CITY OF PORTLAND, MAINE
DEVELOPMENT REVIEW APPLICATION
PLANNING DEPARTMENT PROCESSING FORM

2005-0038

Project Name/Description

RE: 545 Auburn Street (lot #2) – 382A-D-022 – R-2 Zone – application #05-0219

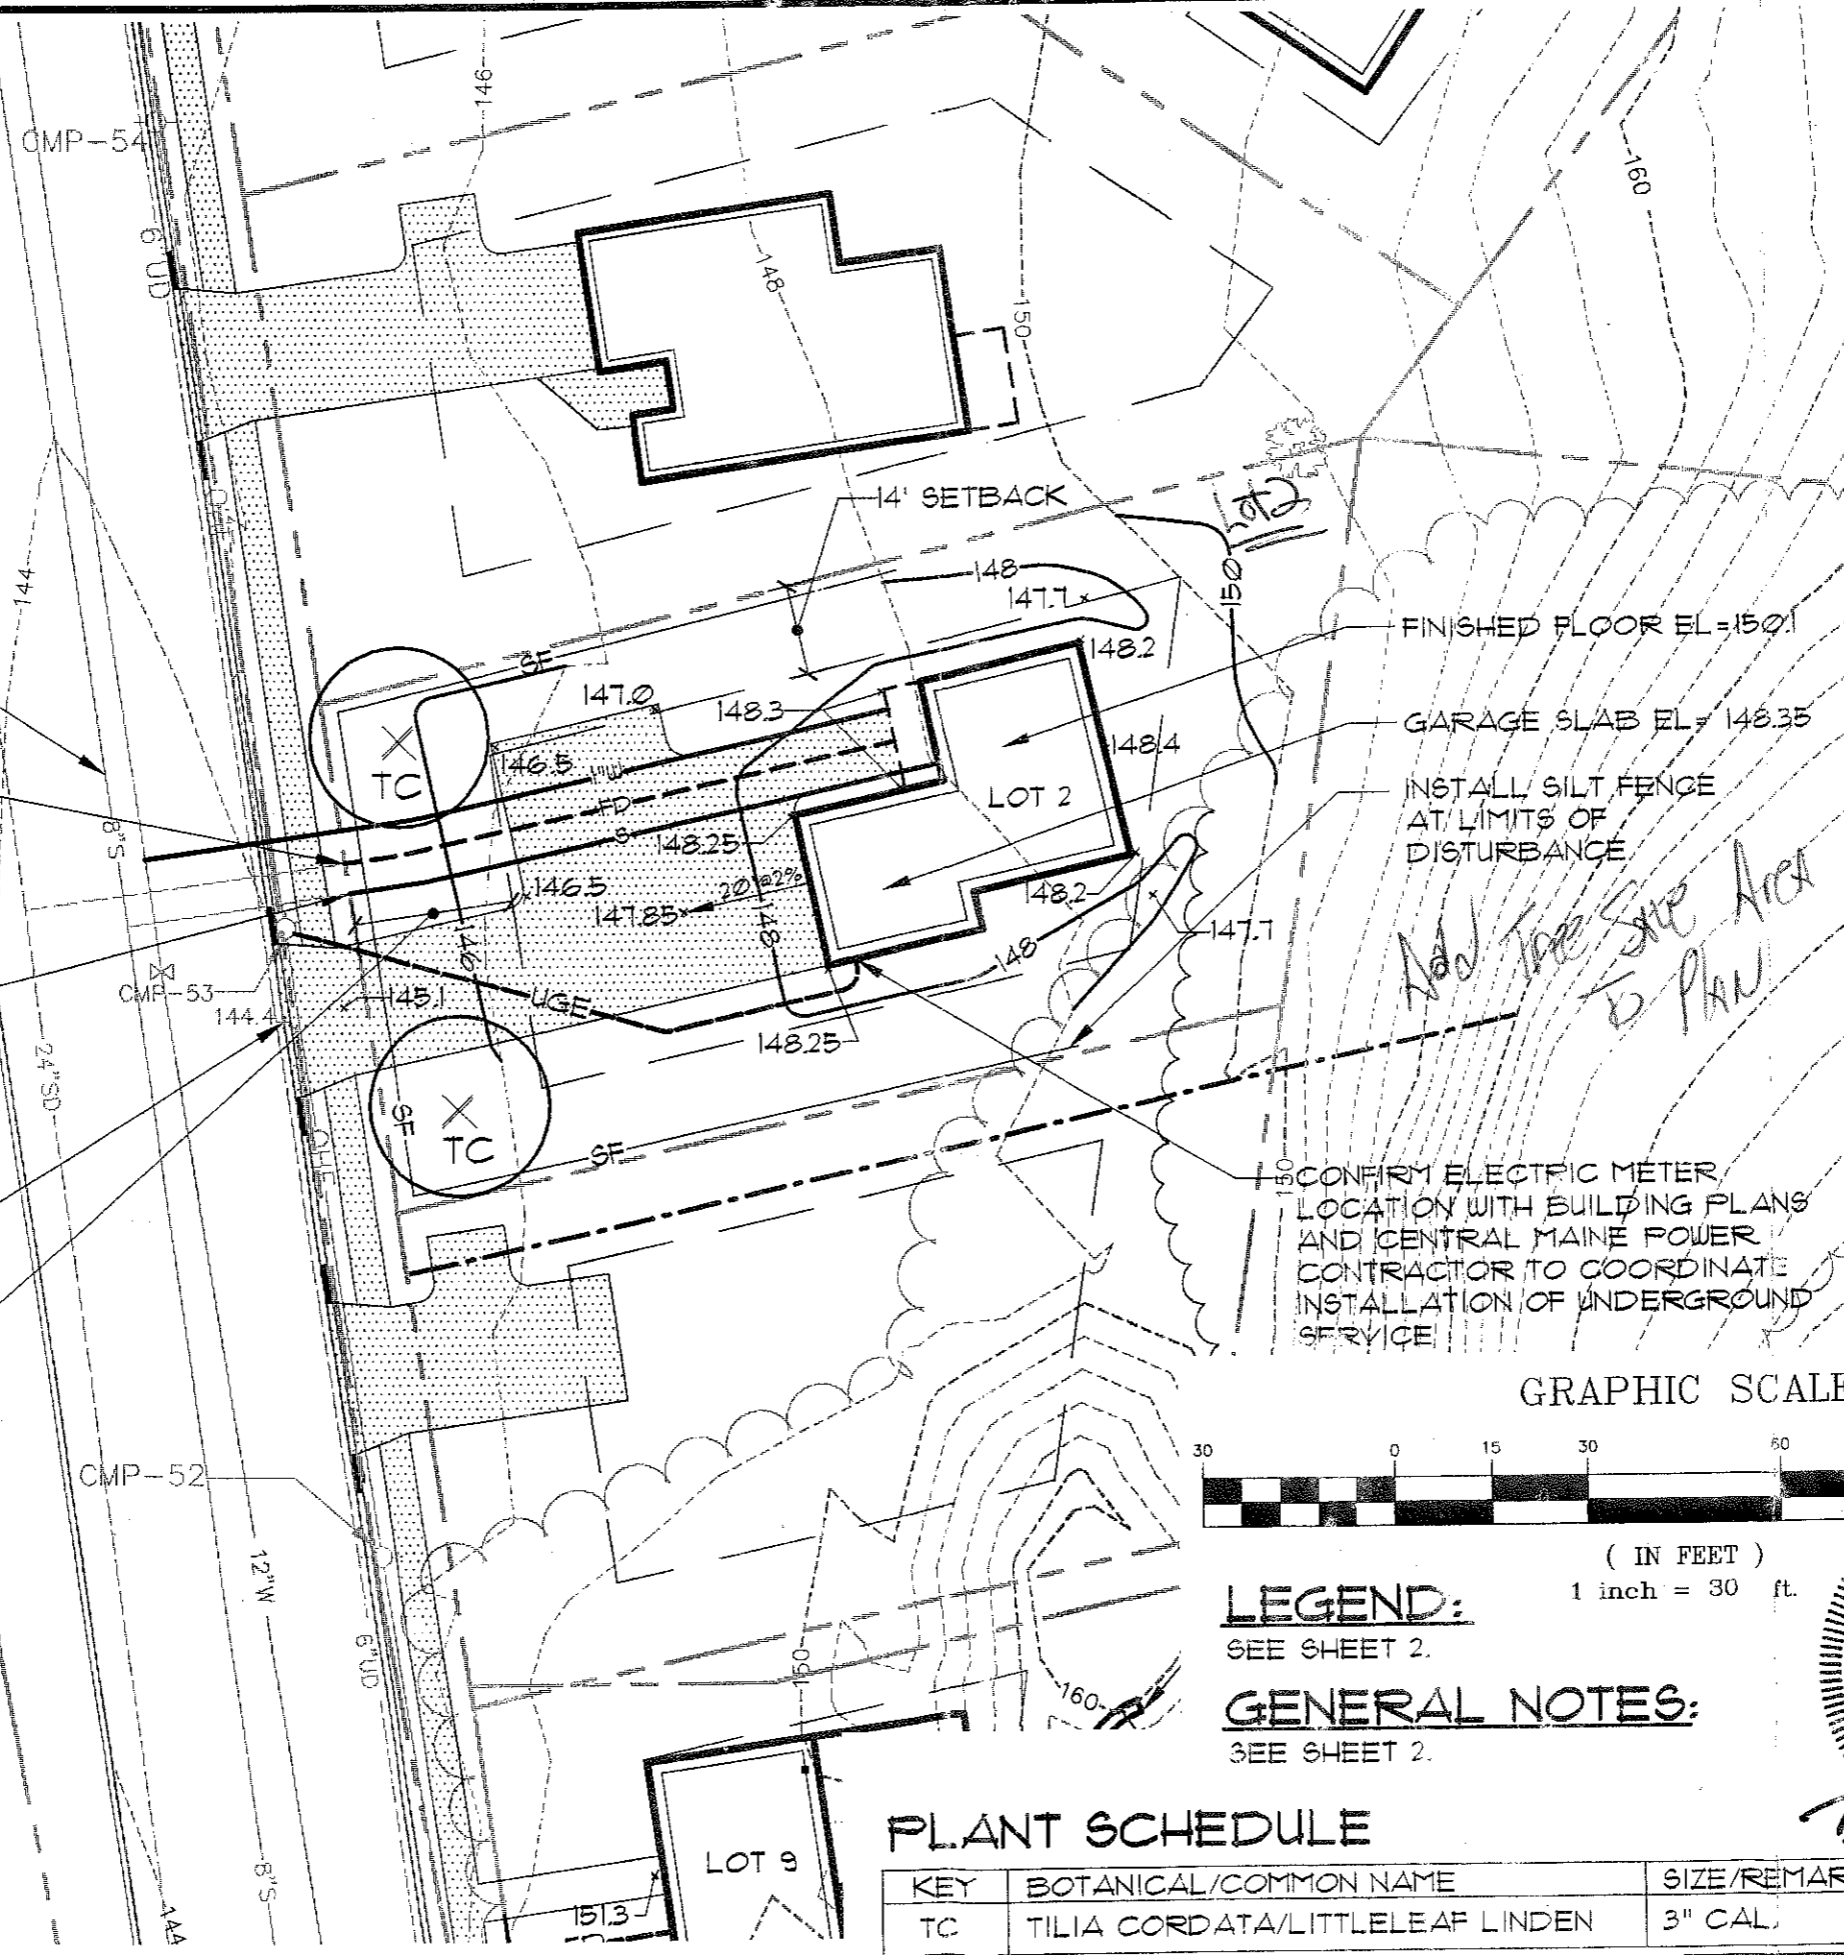
Add Tree-Save Info from
Landscape Plan (Sub. Plans)
To Site Plan.
